62 Ferringham Lane, Ferring – Your ref. FG/123/12

The above property runs along our western boundary and we wish to object to the above application.

DRAWING No. **Drawing 3**

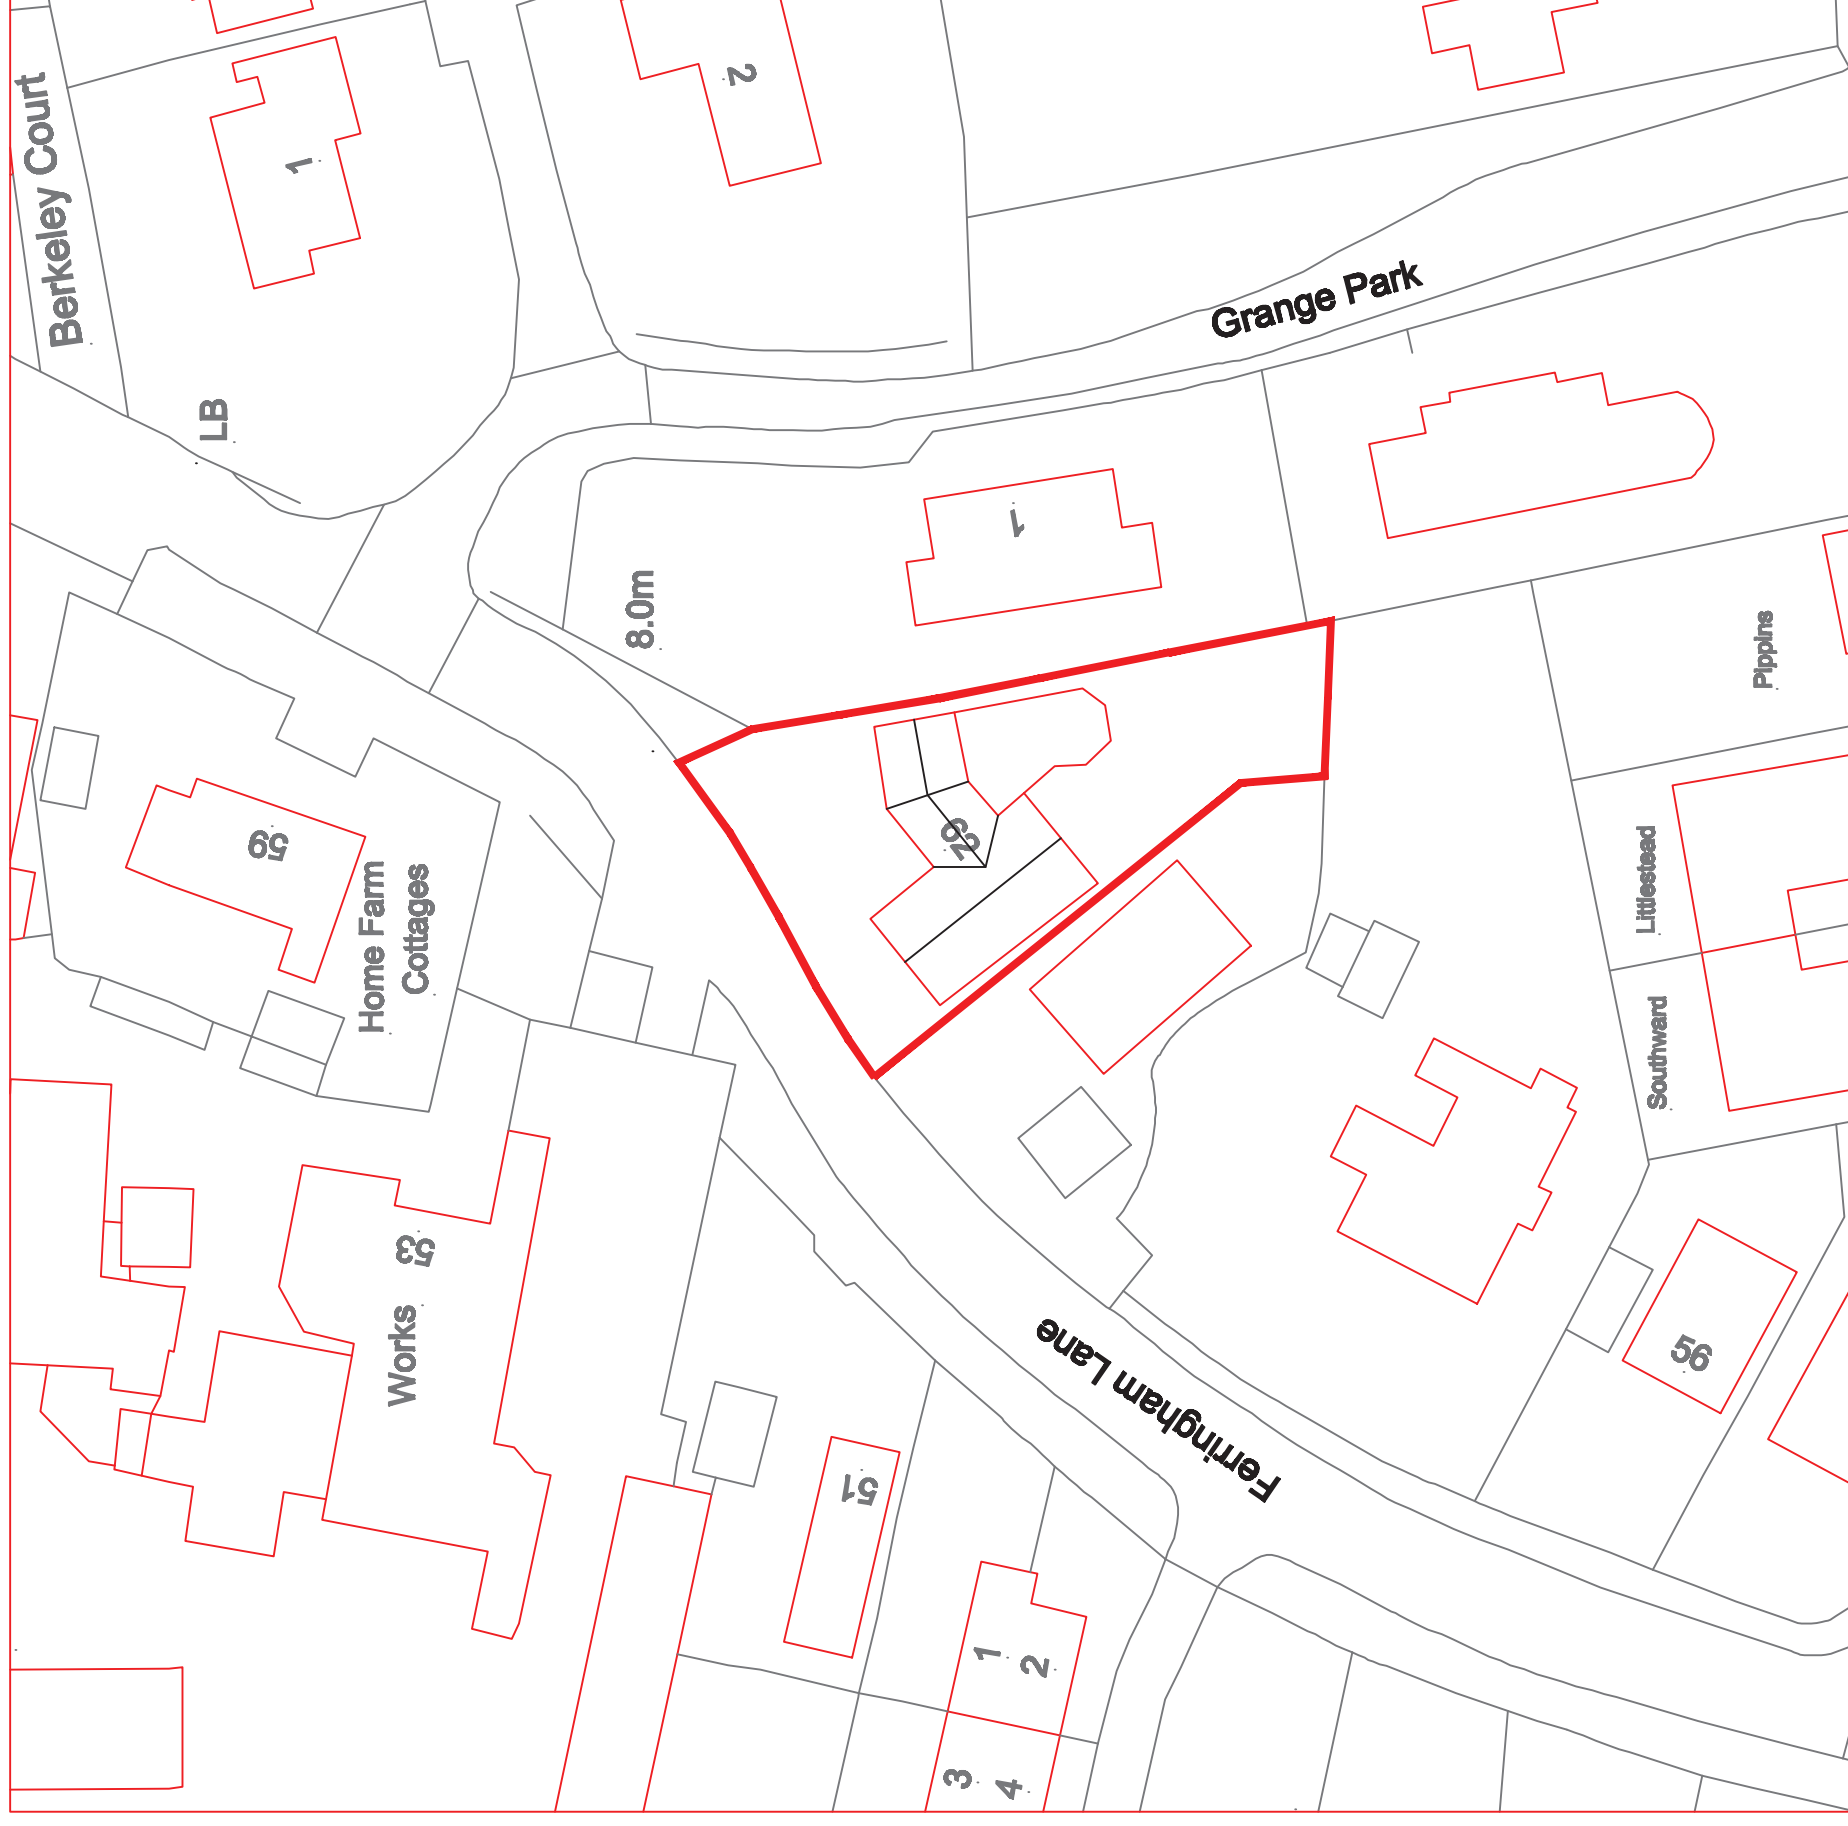
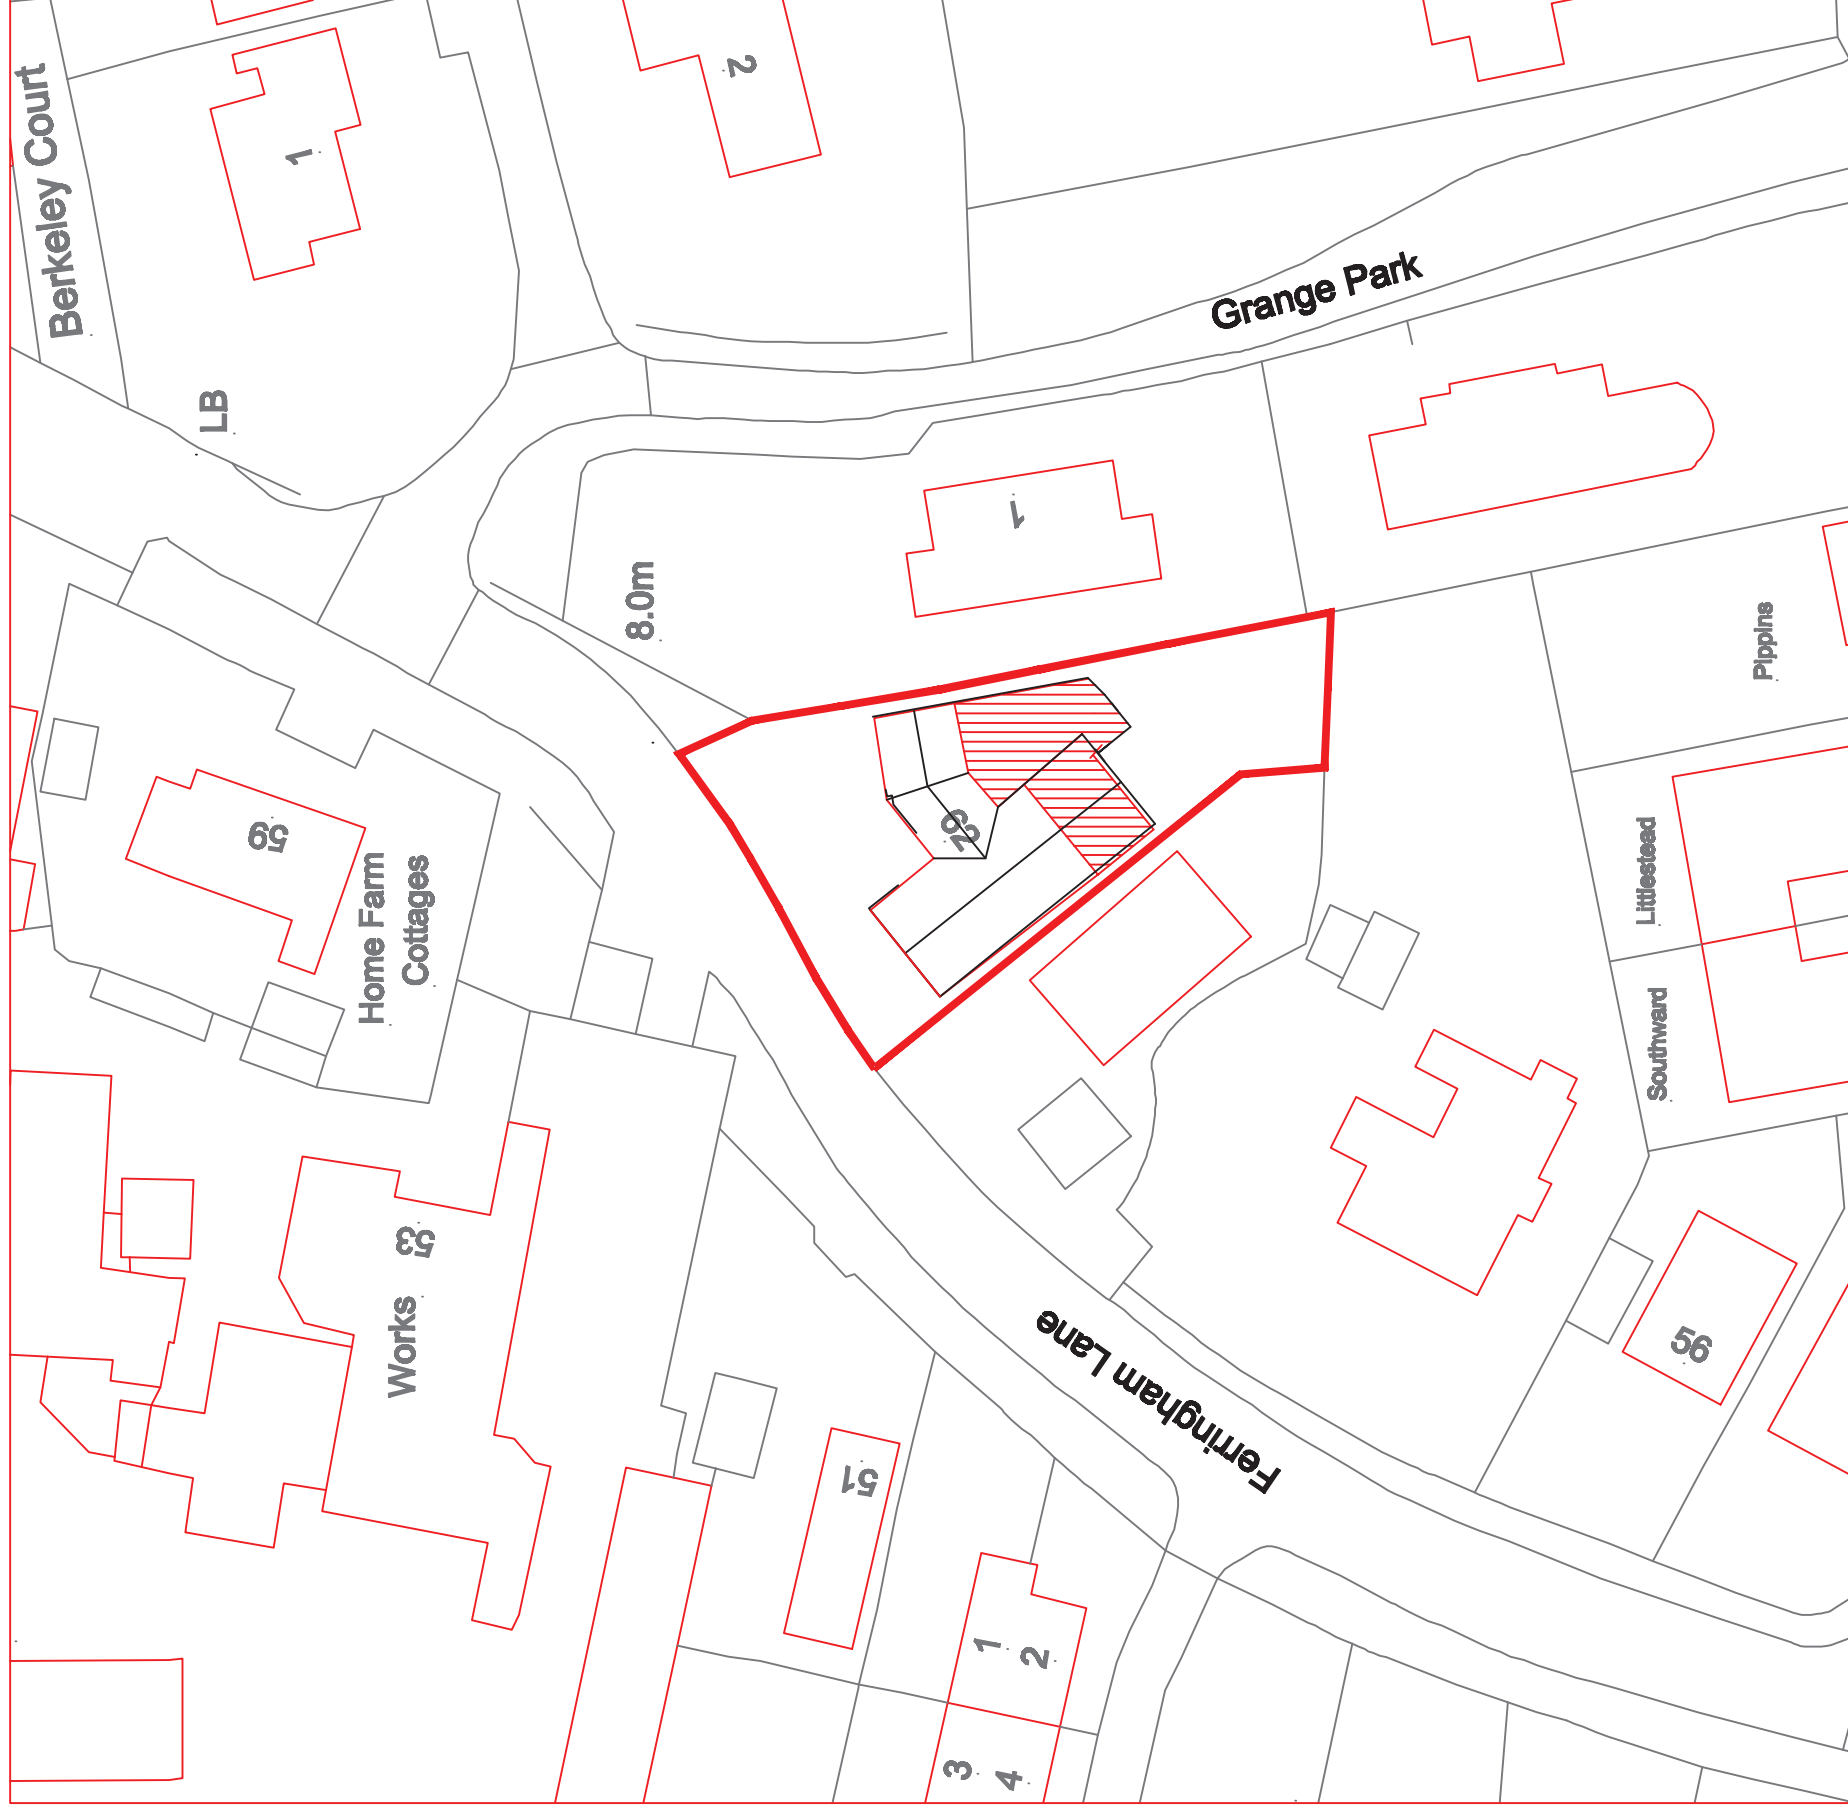
We would like to point out that the website plans do not show heights and do not show a parapet on the south side of the single storey extension. On your website Drawing 3 is described as including a roof plan but all it shows are existing and proposed block plans and a location plan. A roof plan would, presumably, have shown more clearly this parapet and the slope of the roof. Hence we think that the plans do not properly show the building.
